Application No: 20/01118/FUL

Dwelling Address: 44 Hudson Road, Southsea, PO5 1HD

CHANGE OF USE FROM PURPOSES FALLING WITHIN A CLASS C4 (HOUSE IN MULTIPLE OCCUPANCY) TO HOUSE IN MULTIPLE OCCUPANCY FOR MORE THAN 6 PERSONS (SUI GENERIS)

Drawing Title
SUI GEN PLANS

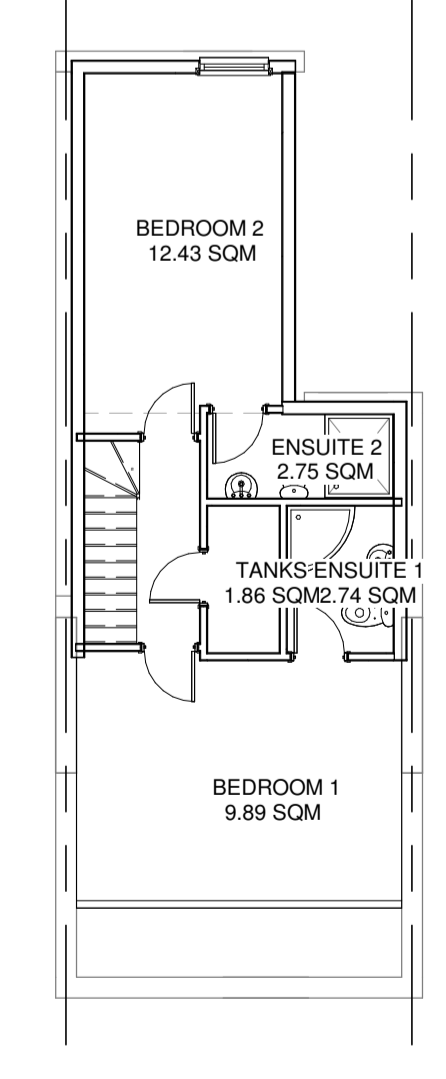
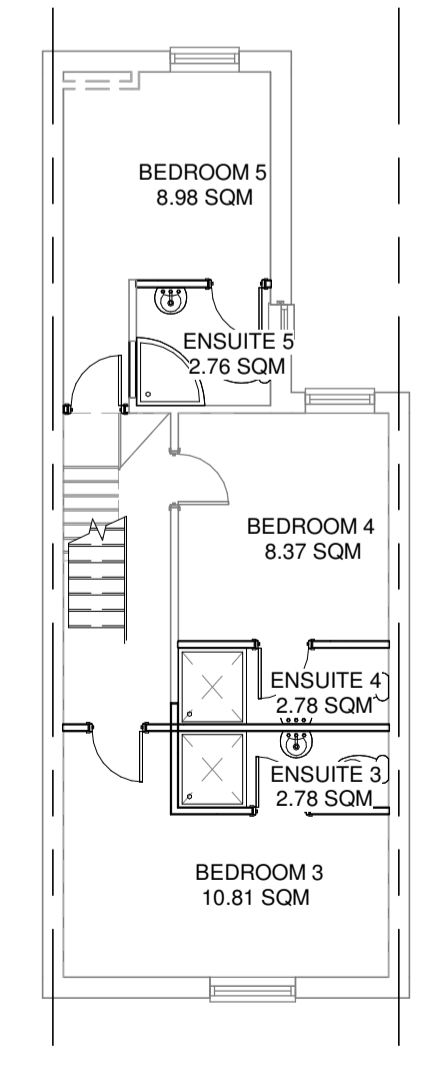
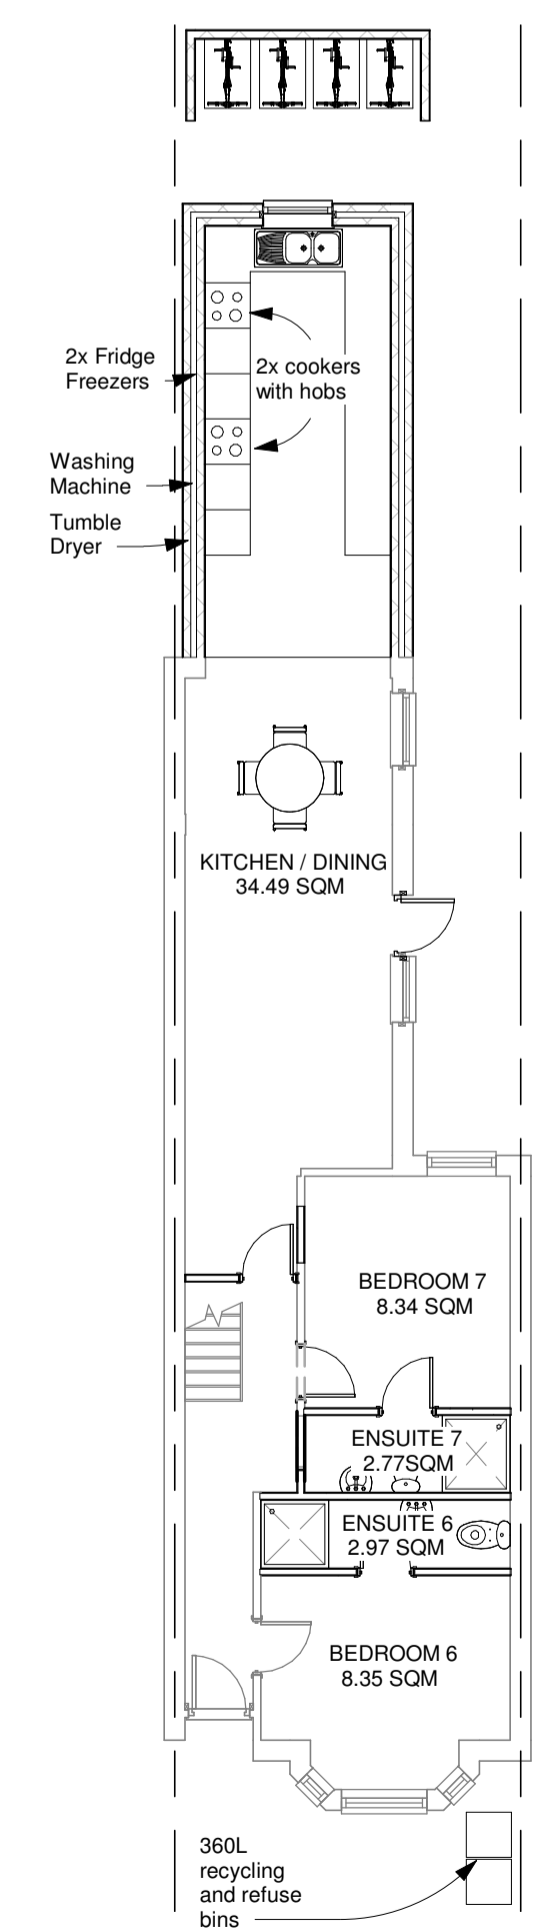
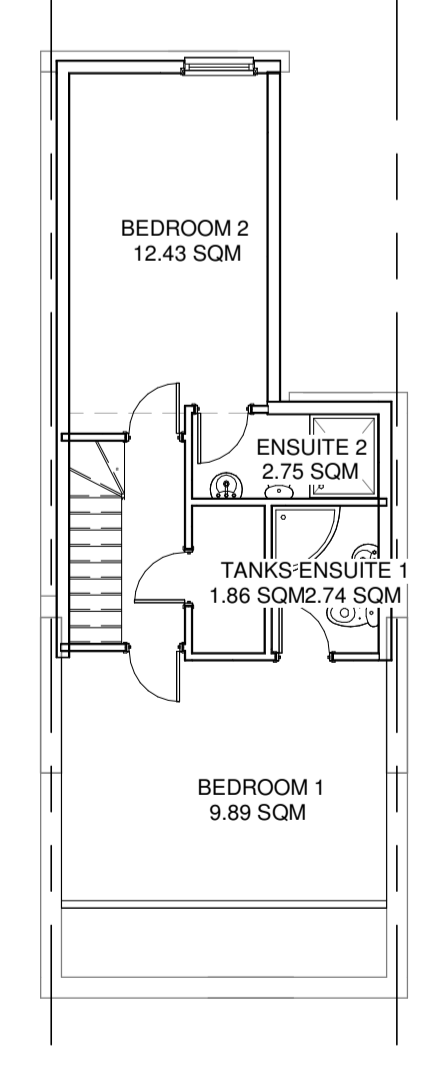
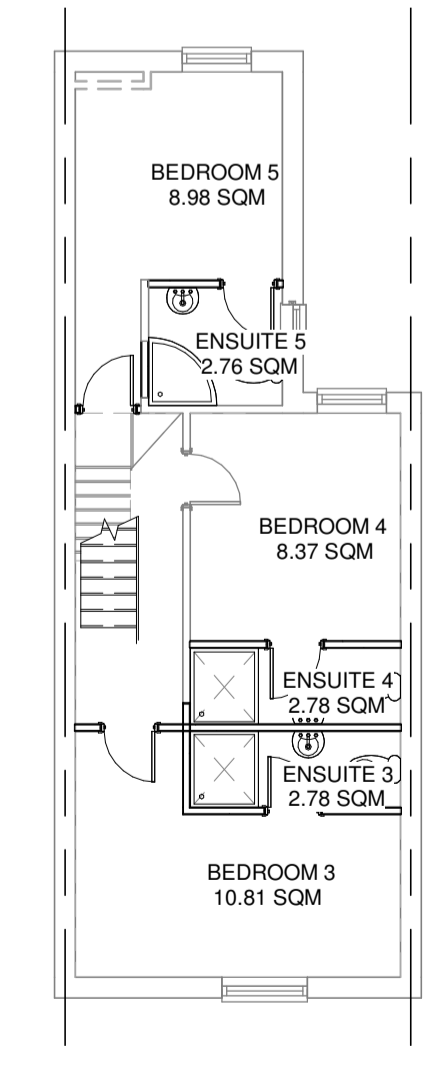
Wash hand basins must be installed in all en-suites and the shower room.

6 Proposed SF SUI GEN
1 : 100

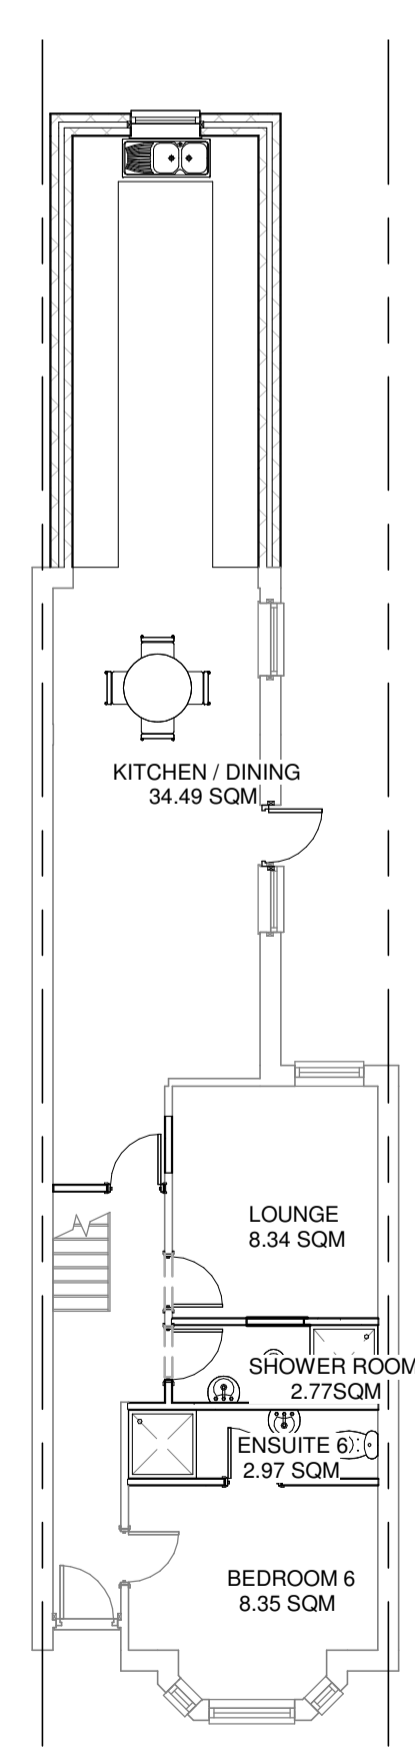
Second floor en-suites must be of a sufficient size to allow adequate activity space.

Appropriate sizes for washing facilities and activity space can be found in the metric handbook.
